Rezoning Transportation Analysis

Petition Number: 2020-099

General Location Identifier: 04705303

Date	Description
08-20-20	First Review
09-22-20	Second Review

REVISIONS:						REV REVISION DESCRIPTION DATE: CHANGED CHEC
DATE:	DESIGN BY:	DRAWN BY:	CHECKED BY:	APPROVED BY:		
	Mallard Creek Townhomes		Charlotte, NC		Bezoning Plan	
): 651032401			09/14/20

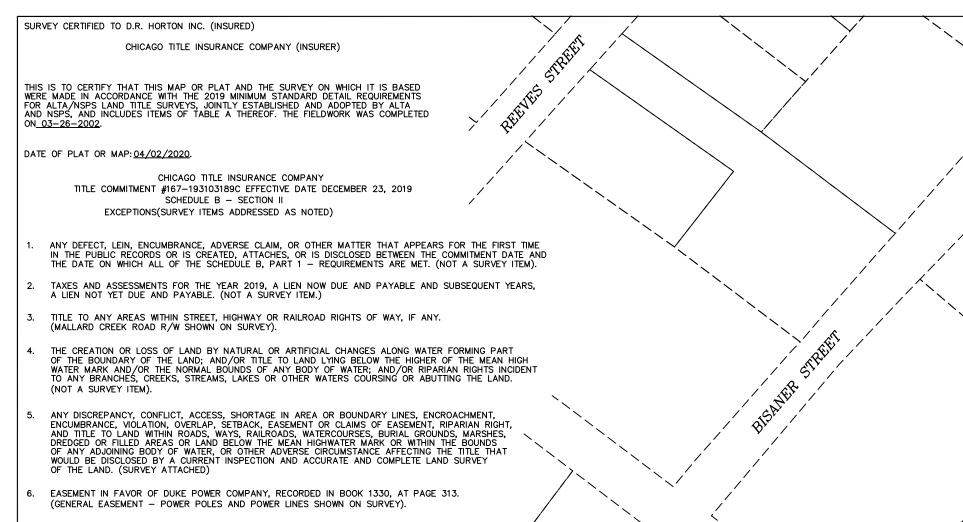
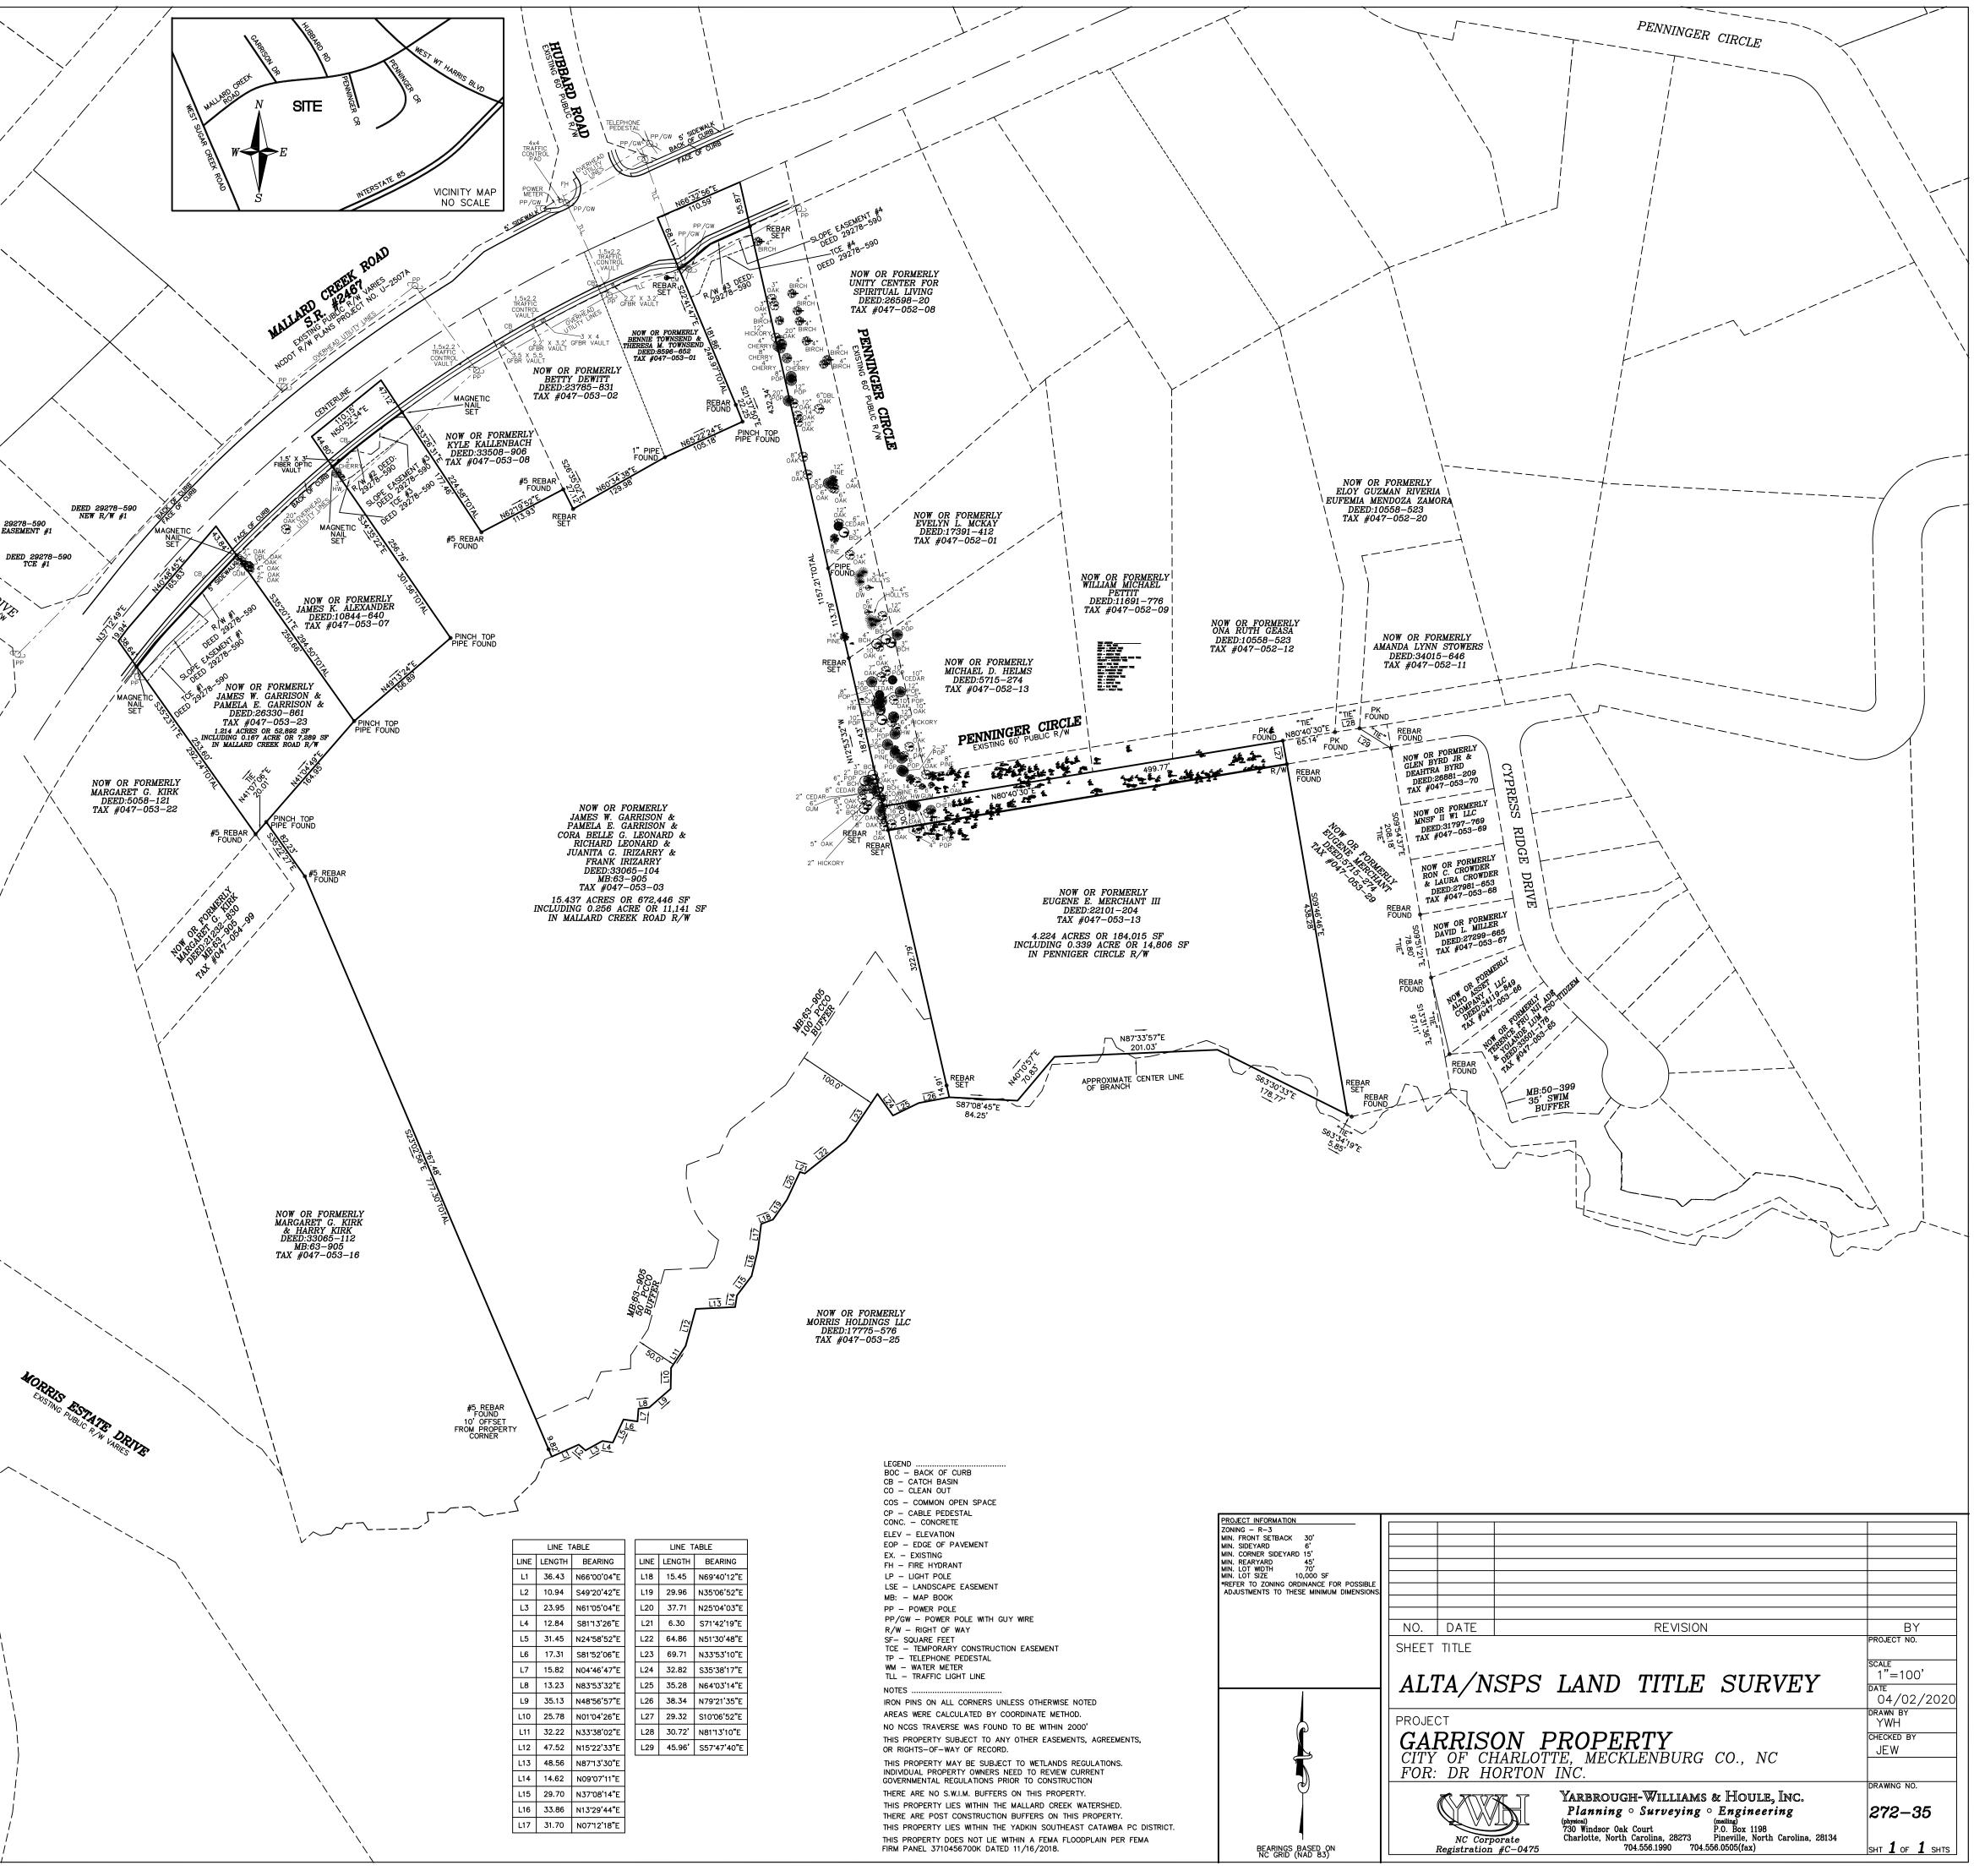
- Outstanding** The petitioner should revise the site plan to include the roadway improvements that will be constructed within NCDOT's STIP (#U-2507A). In accordance with Charlotte BIKES, please provide an 8-ft planting strip and a 12-ft multi-use path, if sidewalk is not constructed within the STIP.

- Technical Clarification (site plan dated 09/14/20)** The petitioner should clarify conditional note (Section 3.G.) that 2-ft of additional right-of-way should be dedicated from back of the 12-ft multi-use path. The petitioner should construct a 12-ft multi-use path where the existing sidewalk is removed for the proposed right-turn lane. Where the existing sidewalk remains undisturbed along the property frontage, CDOT requests for the existing sidewalk to be widened to 12-ft, in accordance with Charlotte BIKES.

- Outstanding** The petitioner should revise the site plan and conditional note(s) to confirm adequate intersection sight distance, according to CDOT's Sight Distance Policy, for access proposed on Mallard Creek Road.

- a. **Technical Clarification (site plan dated 09/14/20)** The petitioner should clarify whether front-loaded or rear-loaded units are proposed. If front-loaded, the petitioner should commit to pair shared driveway aprons with every two units, to preserve the proposed planting strip and sidewalk within the public right of way. This request limits the number of curb cuts, promotes walkability, and preserves a quality streetscape.

- a. **Technical Clarification (site plan dated 09/14/20)** The petitioner should clarify conditional note (Section 3.D.) that a proposed right-turn lane will be constructed at the proposed Mallard Creek Road right-in/right-out access. The proposed right-turn lane should have 100 linear feet of storage with the appropriate bay taper length, according to NCDOT design standards.

- a. **Technical Clarification (site plan dated 09/14/20)** The petitioner should clarify the site plan to show and call-out the existing Penninger Circle private drive that ties into existing Mallard Creek Road. CDOT requests the petitioner to clarify that the existing Penninger Circle road improvements will be constructed in accordance with *CLDSMU-02 - Local Residential Medium Section* cross section design standards, on both sides of the existing Penninger Circle road centerline.
